**Subject: CBD and South East Light Rail (SSI 6042) Modification No.1
Response by Sydney Water.**

Additional impacts relating to the CBD and South East Light Rail On Sydney Water's Assets.

Modification No.1

Figure 5.7 Indicative section – Grosvenor Street stop

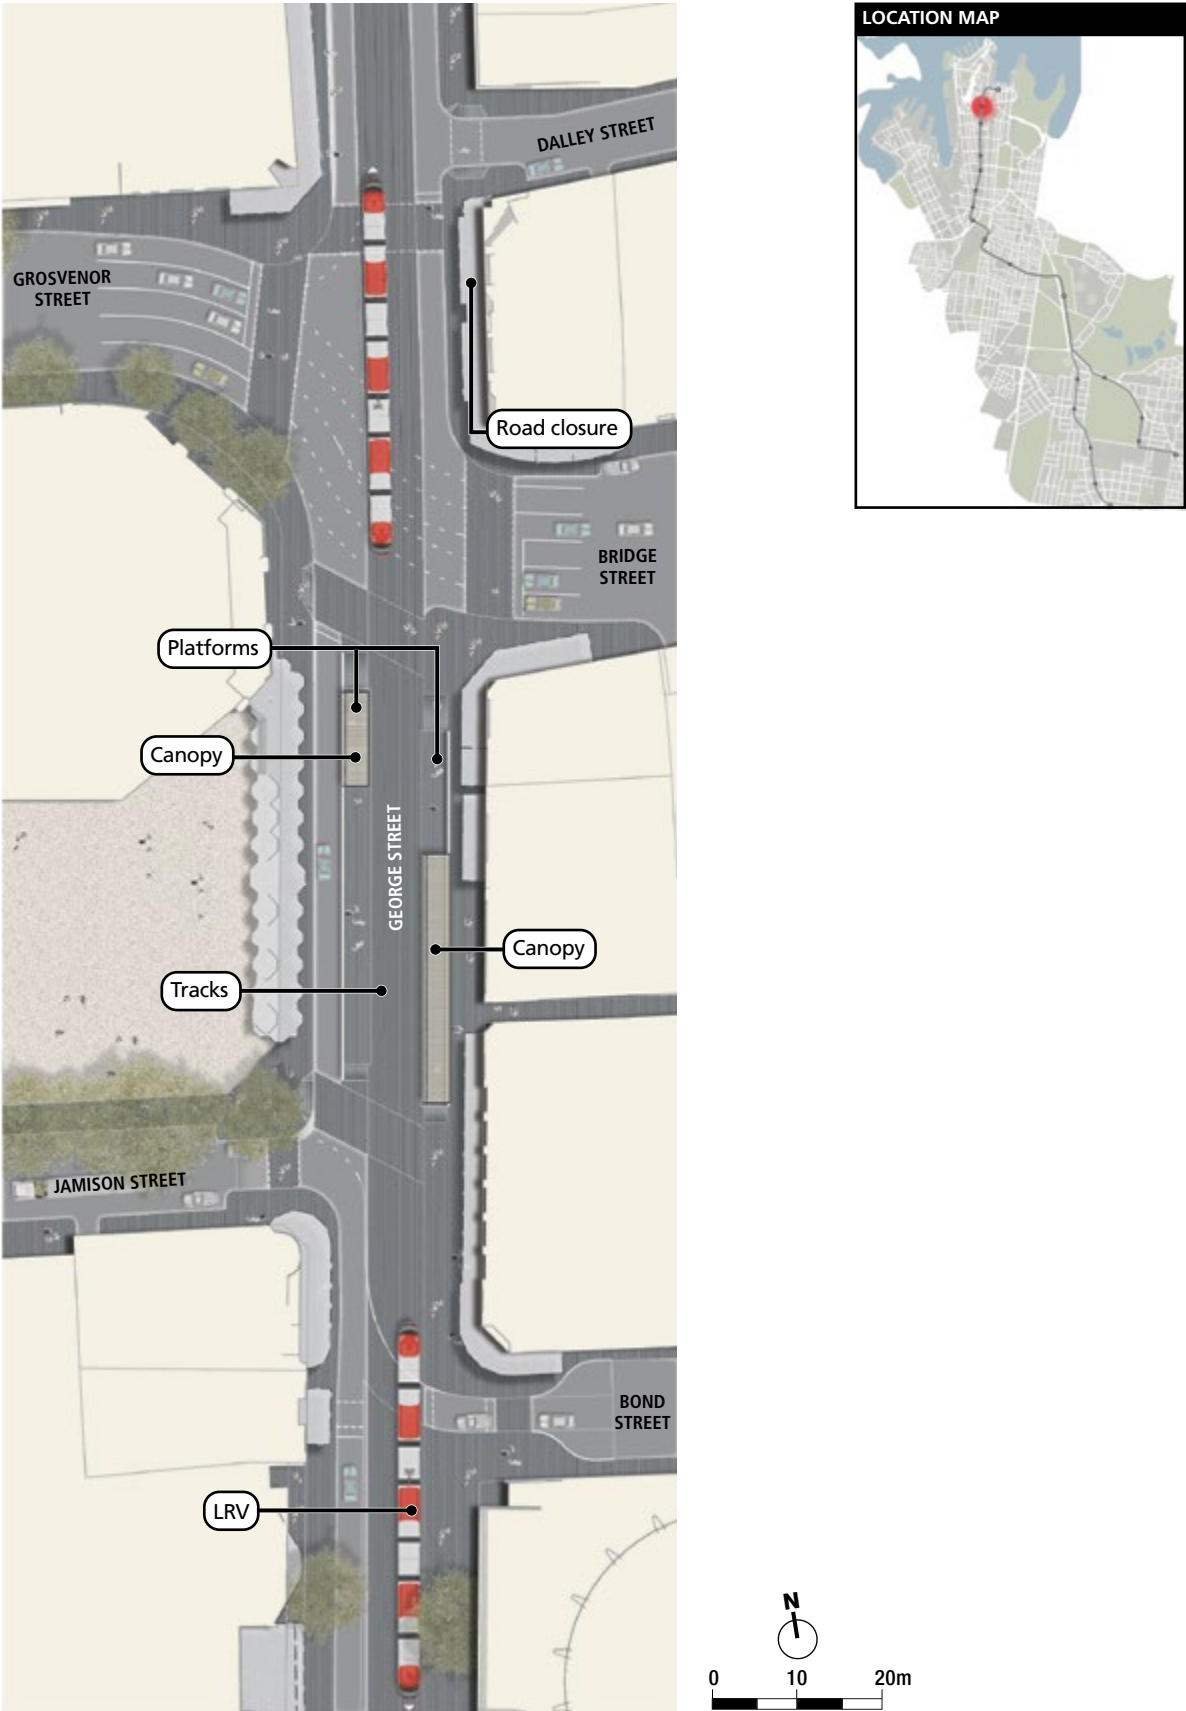
Modification Report	Sydney Water's Comment
Clause 3.3 - Grosvenor Street Stop	The widening of the corridor at the stop on the western side will impact on the DN225 sewer pipe and various maintenance chambers. The sewer & MH may require adjustment.
Clause 3.4 -Removal of World Square stop	No comment
Clause 3.5-Moore Park Stop arrangement	No comment
Clause 3.6 -	No comment
Clause 3.7 – Realignment along Alison Rd Royal Randwick Race Course	<ul style="list-style-type: none"> The track access into stabling and maintenance facility will impact on; <ul style="list-style-type: none"> DN1650 Conc. Stormwater pipe. DN600 & DN450 CICL watermain Scour valves between the watermain and stormwater pipe. DN450 CI sewer pipe. The revised alignment will impact on : <ul style="list-style-type: none"> Vent line and vertical vent shaft east of modified stop. Crossing DN600 CICL & DN450 CICL watermain at Darley St Crossing DN300 & DN 225 sewer and MH at Darley St The regrading of Alison Rd footpath for the retaining wall may reduce the cover over the 600 CICL watermain. Construction activity along the realignment may impact on the 600 CICL watermain. A geotechnical & structural assessment will be required to determine the impact. Adjustment or protection of assets may be required.
